Recommendation Report for Outline Consent

REF NO:	BN/65/19/OUT
LOCATION:	Bexstone House Barnham Road Eastergate PO20 3RT
PROPOSAL:	Outline application with some matters reserved for the demolition of existing dwelling & erection of 10 No. new dwellings, widening & reprofiling of site access, provision of a right turn lane with improved visibility splays, retention of significant landscaped highway buffer, parking for 30 No. cars including garages & visitor parking & potential future highway access to adjacent housing land (resubmission following EG/49/18/OUT).

Designers Response demonstrating moved Island /

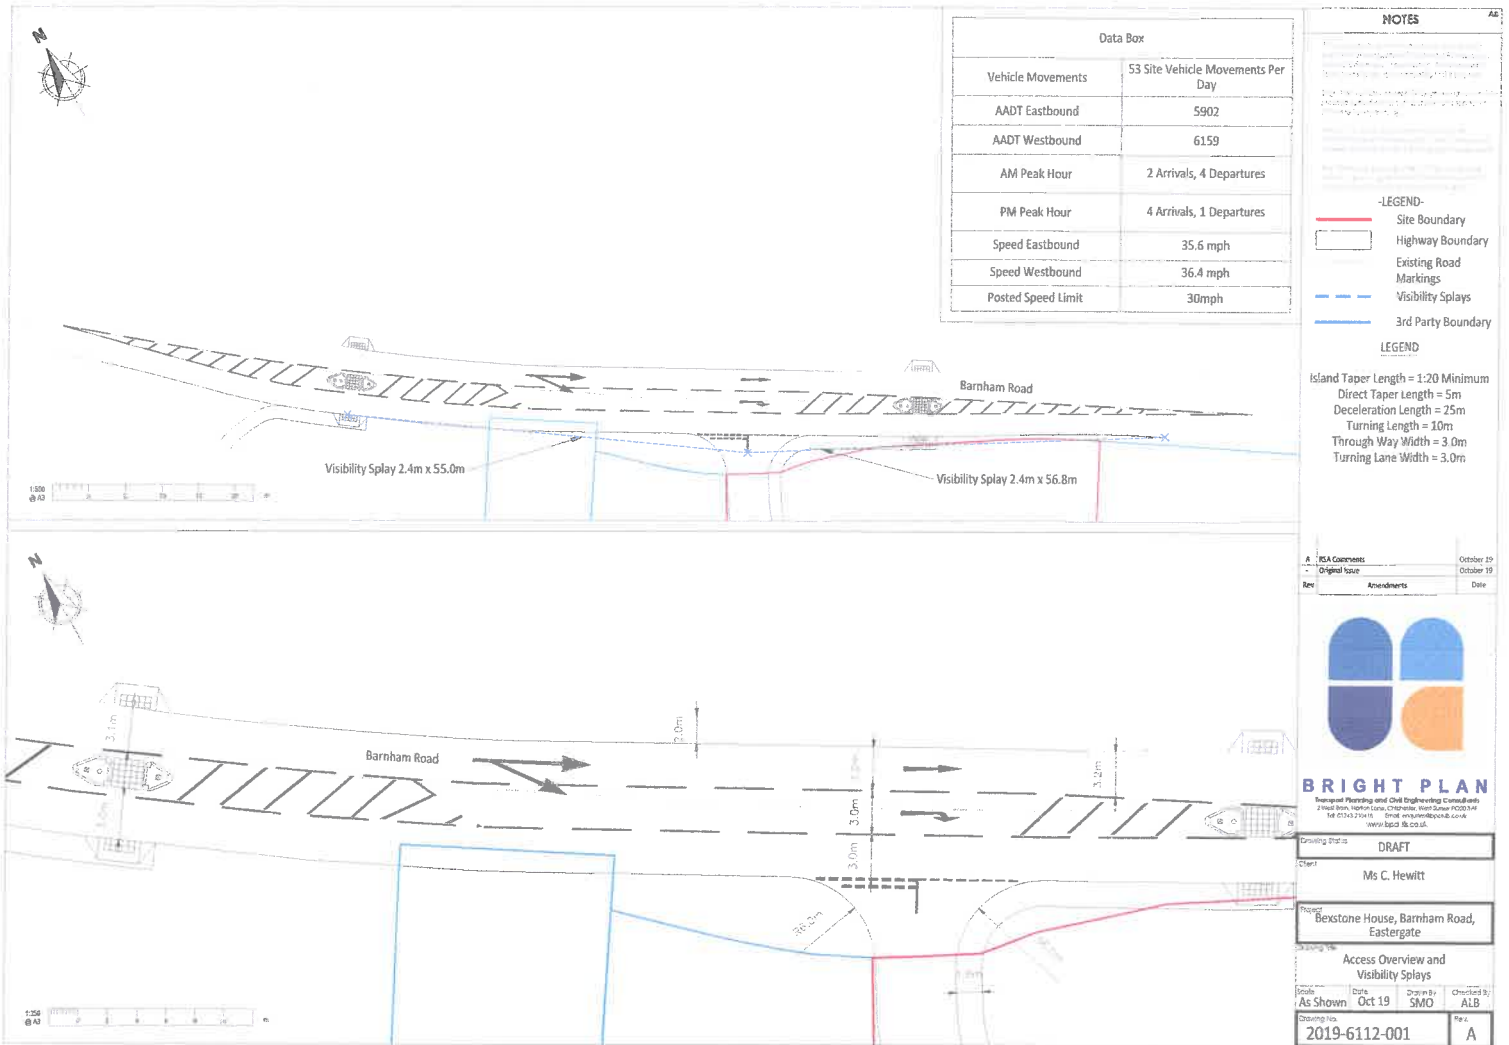
- The right hand filter lane would cause vehicles to idle and accelerate into the turning causing disturbance.
- The proposed pedestrian and cycle crossing on Barnham Road would restrict access to the driveway to the house opposite as it is to be positioned in the middle of the dropped kerb of the house opposite.

- Pedestrians and cyclists would congregate on the driveway while waiting to cross the road.
- The proposed pedestrian and cycle crossing would significantly increase the risk of accident.
